Lower Thames Crossing

5.4.1.4 Final Agreed Statement of Common Ground between (1) National Highways and (2) Kent Downs AONB Unit (Clean version)

DATE: December 2023
DEADLINE: 9A

Planning Inspectorate Scheme Ref: TR010032
Application Document Ref: TR010032/APP/5.4.1.4

*Local Landscape Character Area boundaries of the Kent Downs AONB LCA, West Kent Downs, Sub-areas Cobham and Shorne*

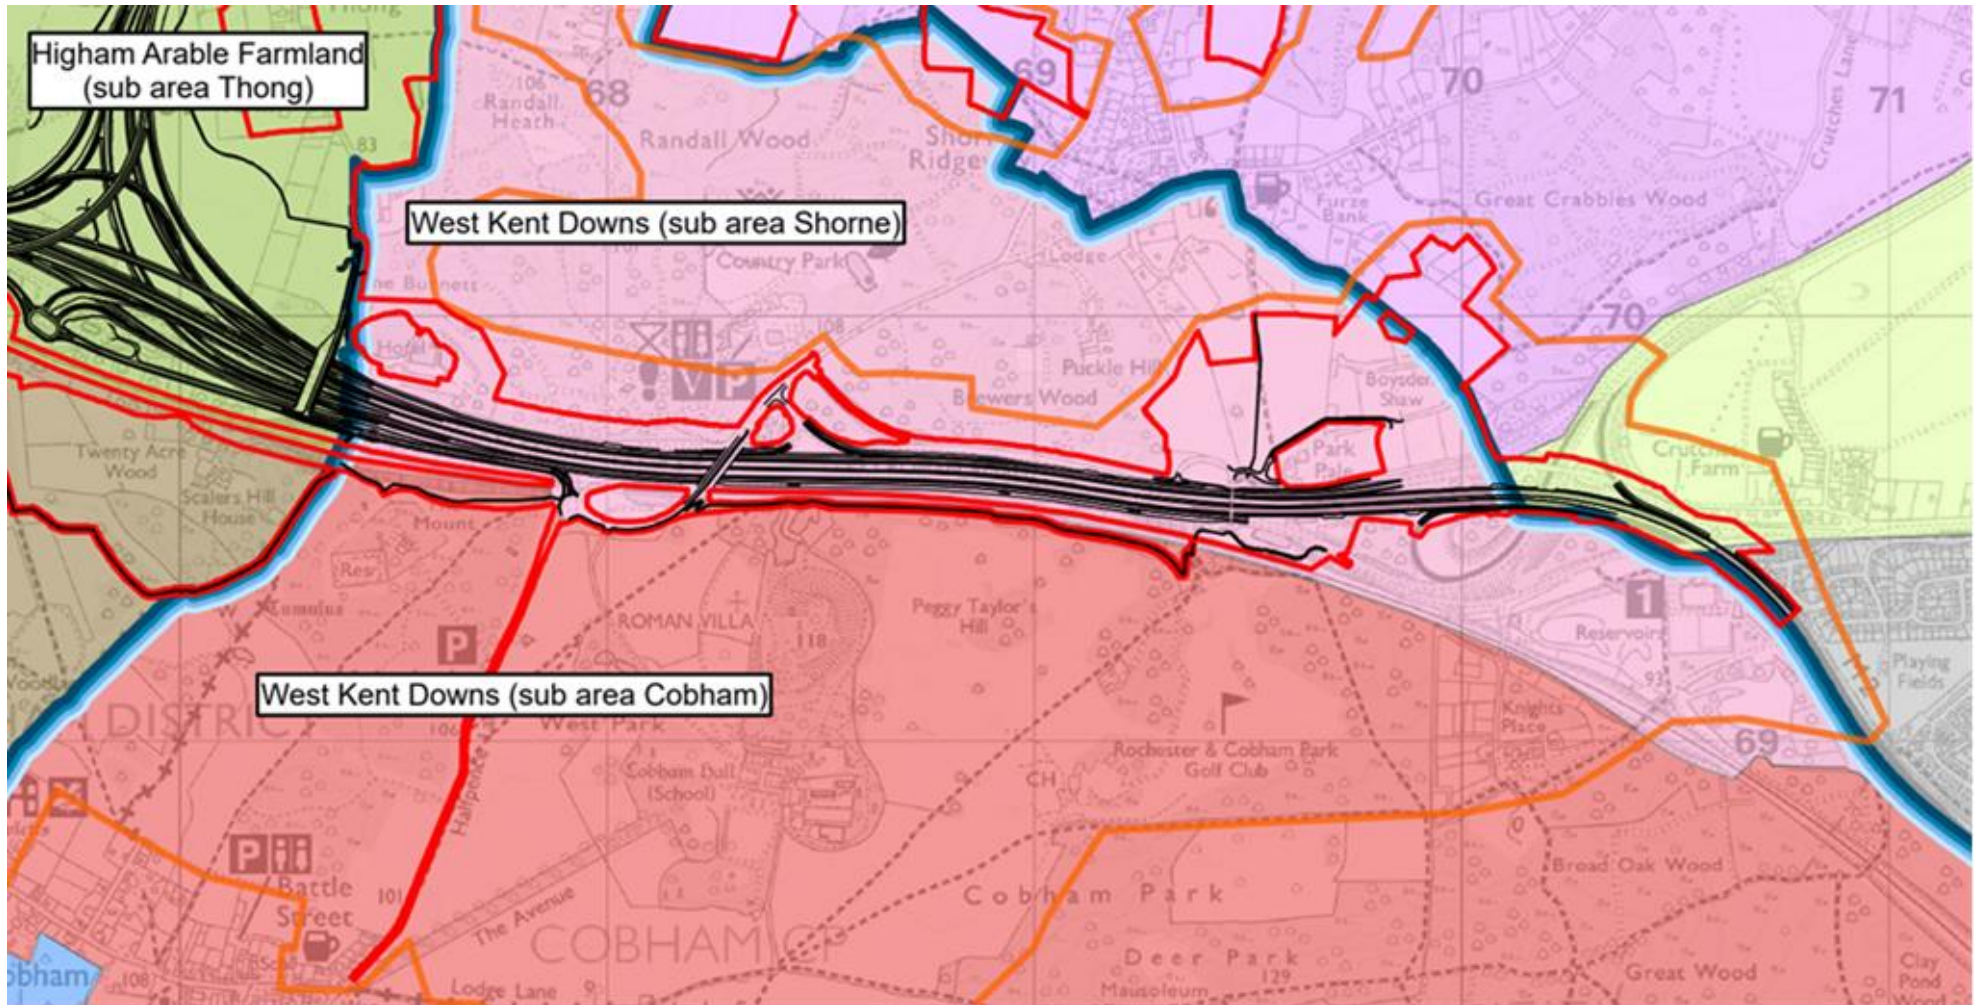
Topic	Item No.	Kent Downs AONB Unit Comment	The Applicant's Response	Application Document Reference	Status
			Thong Village, Cobham and the businesses along the A2.		
Landscape & Visual					
Baseline	2.1.42 WR (DL6)	<p>The LVIA has assessed the impacts on the Kent Downs AONB Landscape Character Areas (LLCA) based on an adjusted plotting of the boundaries of the Shorne and Cobham Subareas of the West Kent Downs Character Areas. This re-adjustment of the boundaries results in less of the proposed works falling within the Cobham sub-area as defined in the LVIA than within the Kent Downs published LCA and conversely, a greater proportion of the works falling within the Shorne sub-area.</p> <p>In respect of the revised assessment submitted at Deadline 8, notwithstanding the AONB Unit's continued contention that the impacts to landscape character at Design Year are generally underassessed, the AONB agrees with the Applicant's assessment set out in the revised landscape impact assessment tables using the non-adjusted boundaries, that the</p>	<p>As detailed in Appendix A of Comments on Written Representations, the boundaries of character areas identified in the studies have been used to inform the definition of the LLCAs, which have been used as a basis for the assessment of effects on the landscape at the local level. In a limited number of locations, the boundaries of the published character areas have been slightly adjusted through detailed study and analysis undertaken for the LVIA in ES Chapter 7.</p> <p>From the Applicant's review of the West Kent Downs (sub area Cobham) LLCA and from its site visits, it is of the view that HS1 and the associated planting strongly define the northern extent of the Cobham sub area, and it therefore made sense for the Shorne sub area to incorporate the whole width of the A2 corridor, beyond HS1. Notwithstanding this slight difference in the West Kent Downs (sub area</p>	<p>ES Chapter 7: Landscape and Visual [Document Reference 6.1 ES Chapter 7 (2)] ES Addendum [Document Reference 9.8 (9)] Comments on WRs Appendix A: Statutory Environmental Bodies [REP2-046] Post-event submissions, including written submission of oral comments, for ISH11 [Document Reference 9.187]</p>	Matter Not Agreed

Topic	Item No.	Kent Downs AONB Unit Comment	The Applicant's Response	Application Document Reference	Status
		<p>impacts of the Project would increase in respect of impacts in the Cobham Sub Area but would remain as reported for the Shorne Sub-area and overarching West Kent Downs LCA. The AONB Unit disagrees that there would be the assessed reduction at Construction in the Shorne Sub-Area from Major to Moderate.</p> <p>The AONB Unit is of the view that as using the adjusted boundaries results in a reduced assessment of the effects for the Cobham Sub-Area, the assessment should be based on the published LCA boundaries.</p>	<p>Cobham) LLCA boundary for the purposes of the assessment, the effects of the Project are fully assessed either as direct or indirect effects within the West Kent Downs (sub area Cobham) LLCA and/or the neighbouring West Kent Downs (sub area Shorne) LLCA. The findings of these two assessments are then brought together into a combined assessment for the overarching West Kent Downs Landscape Character Area (LCA) 1A. The combined effects reported in the landscape impact summary in Tables 7.33 and 7.34 in Section 7.9 of ES Chapter 7: Landscape and Visual and the overall conclusion of the landscape and visual impact assessment would therefore not differ if the Cobham and Shorne sub area boundary is drawn in a different location.</p> <p>The Applicant has published a without prejudice assessment using the published LLCA boundaries for Deadline 8.</p>
